**TOWN AND COUNTRY PLANNING ACT 1990 – SECTION 73: APPLICATION FOR VARIATION OF A  
CONDITION FOLLOWING GRANT OF PLANNING PERMISSION: A/122/19/OUT – LAND OFF ARUNDEL  
ROAD, ANGMERING**

We write on behalf of Gladman Developments Ltd and Redrow Homes Ltd to support the submission of an application to vary Conditions 4 and 16 of planning permission A/122/19/OUT, made under Section 73 of the Town and Country Planning Act 1990.

This submission is seeking to substitute the approved proposed secondary access drawing 2020-F03 Rev B with amended drawing C86473-JNP-66-XX-SK-T-7007-P01 which provides an alternative technical solution for the secondary access road that is viable and deliverable to serve the land identified as the Employment/Commercial Centre within the outline planning permission.

Title:
**Commercial Access - General Arrangement
1no Footway, North Side**

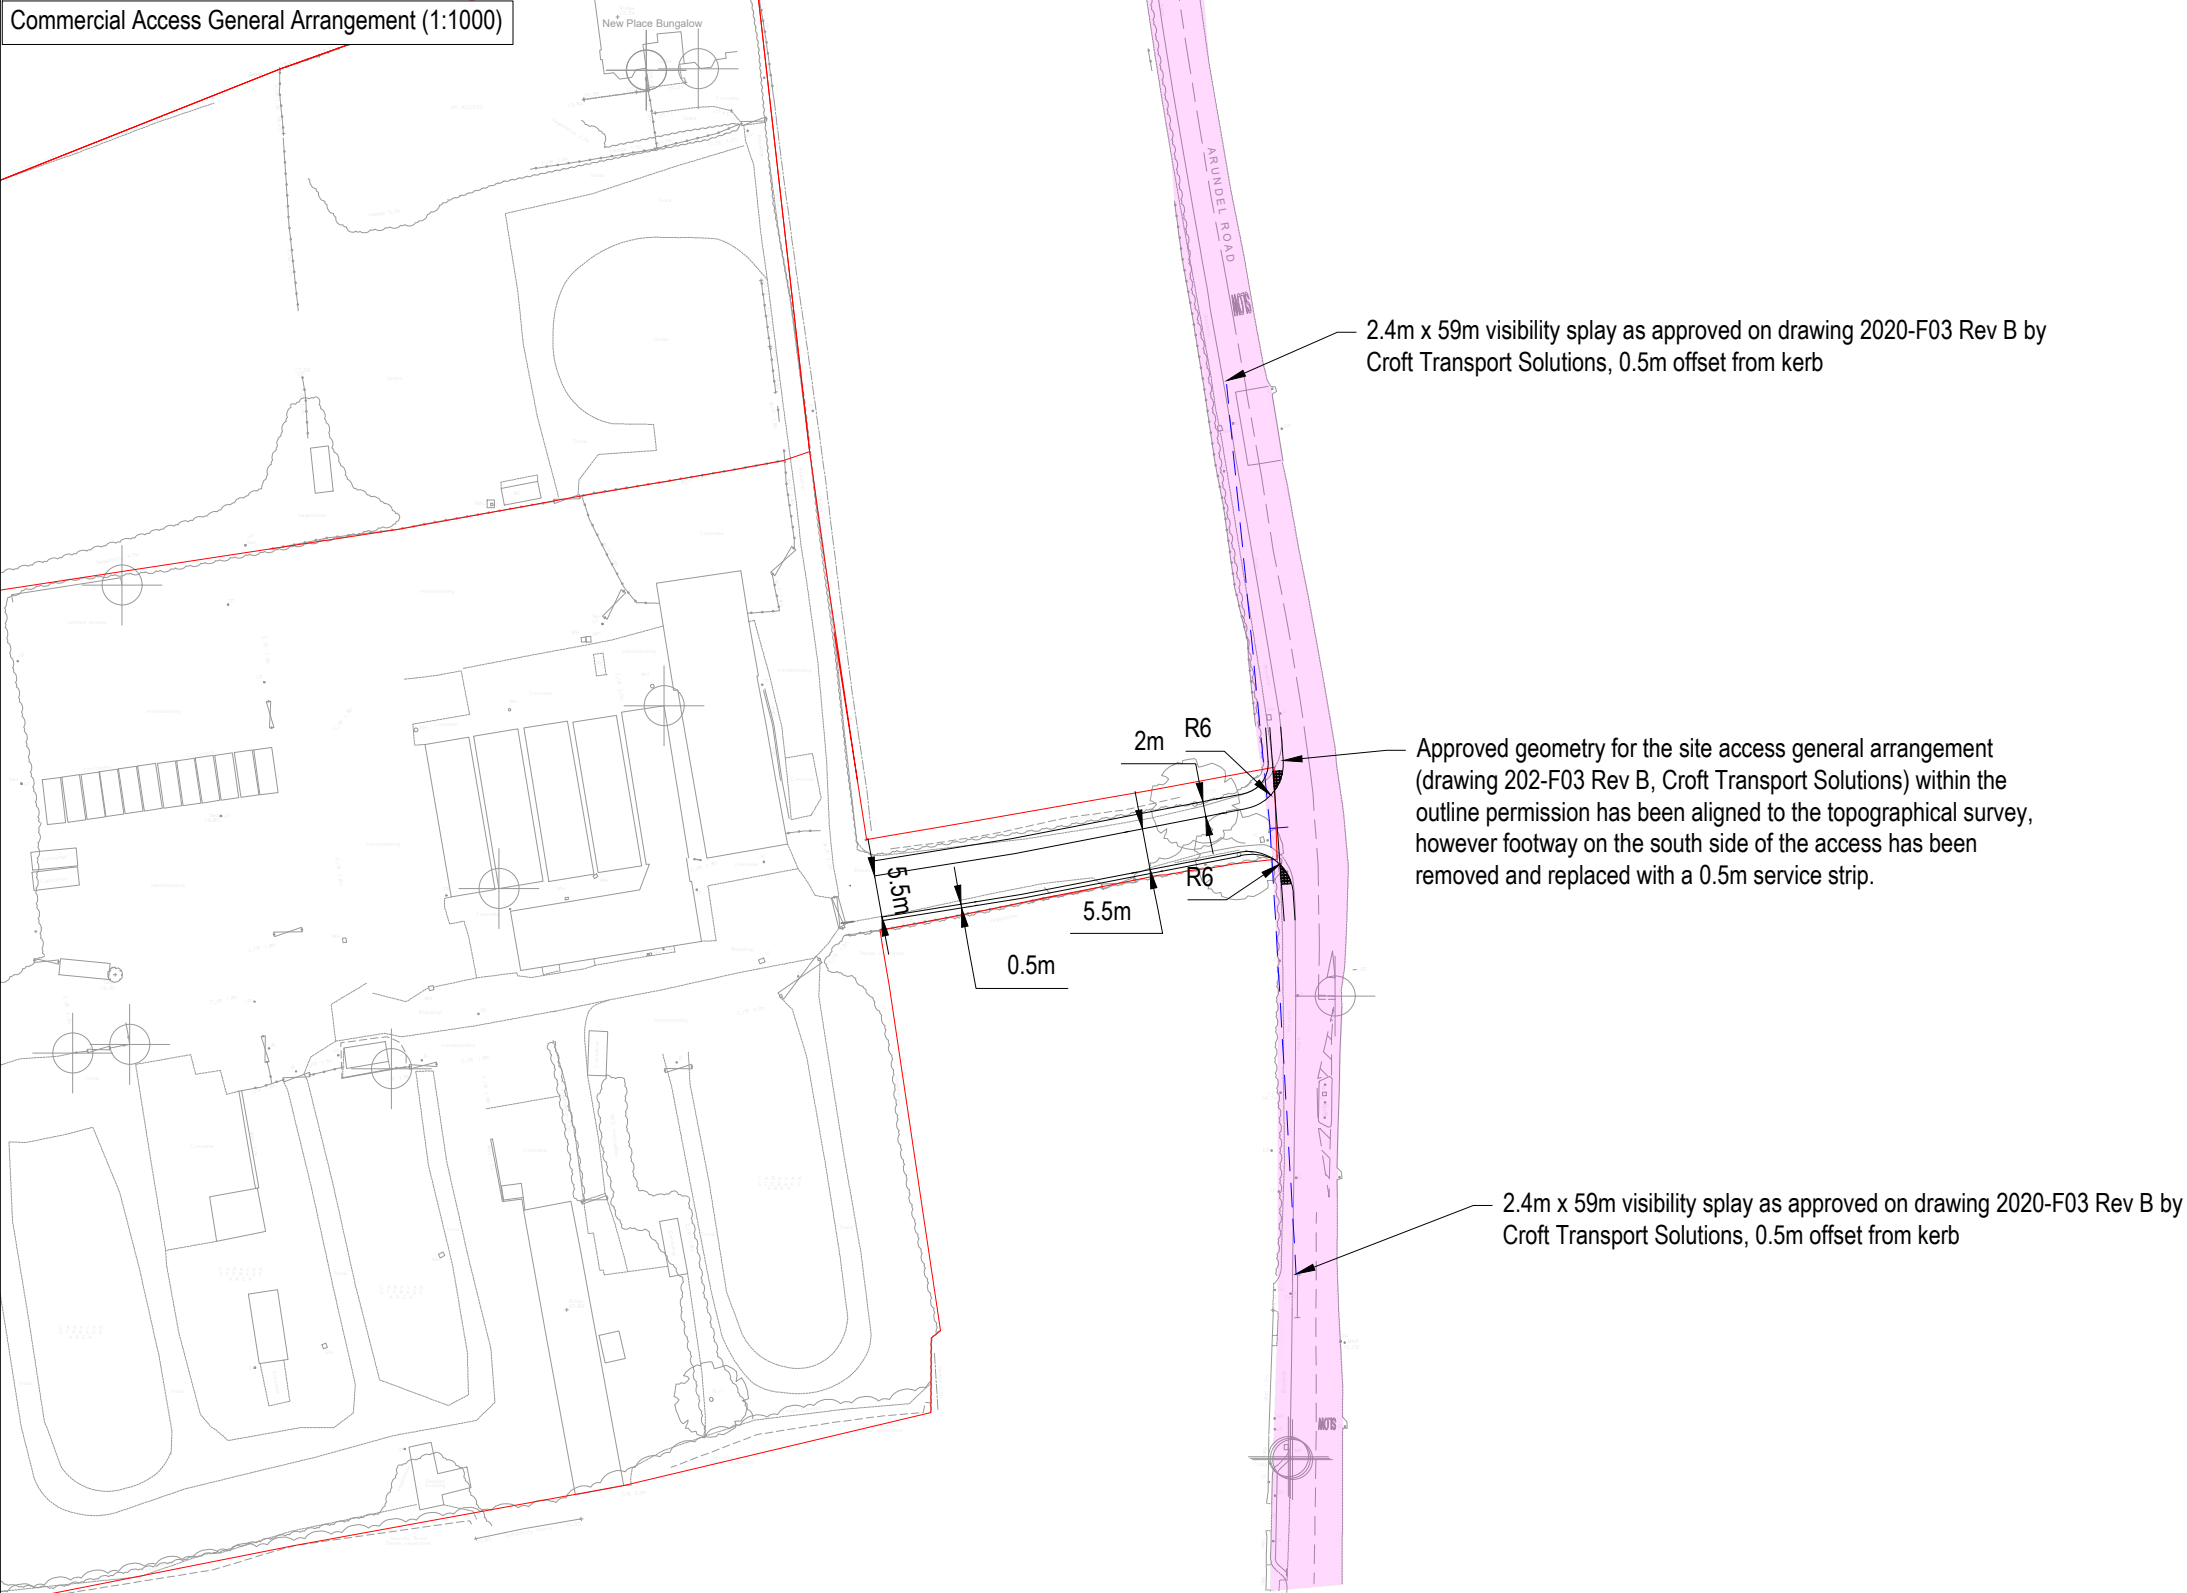
In light of the requirement to amend the technical details associated with the approved secondary access into the site (drawing reference: 2020-F03 Rev. B), we wish to vary the relevant conditions that require the access to be delivered in line with the approved drawings to reflect the amended access arrangements.

**Drawing Number C86473-JNP-66-XX-SK-T-7007-P01 – Commercial Access – General Arrangement 1no**

**Footway, North Side**

No part of the Employment/Commercial Centre shall be first occupied until such time as the vehicular access serving the development has been constructed in accordance with the details shown on **Drawing Number C86473-JNP-66-XX-SK-T-7007-P01 – Commercial Access – General Arrangement 1no Footway, North Side.**
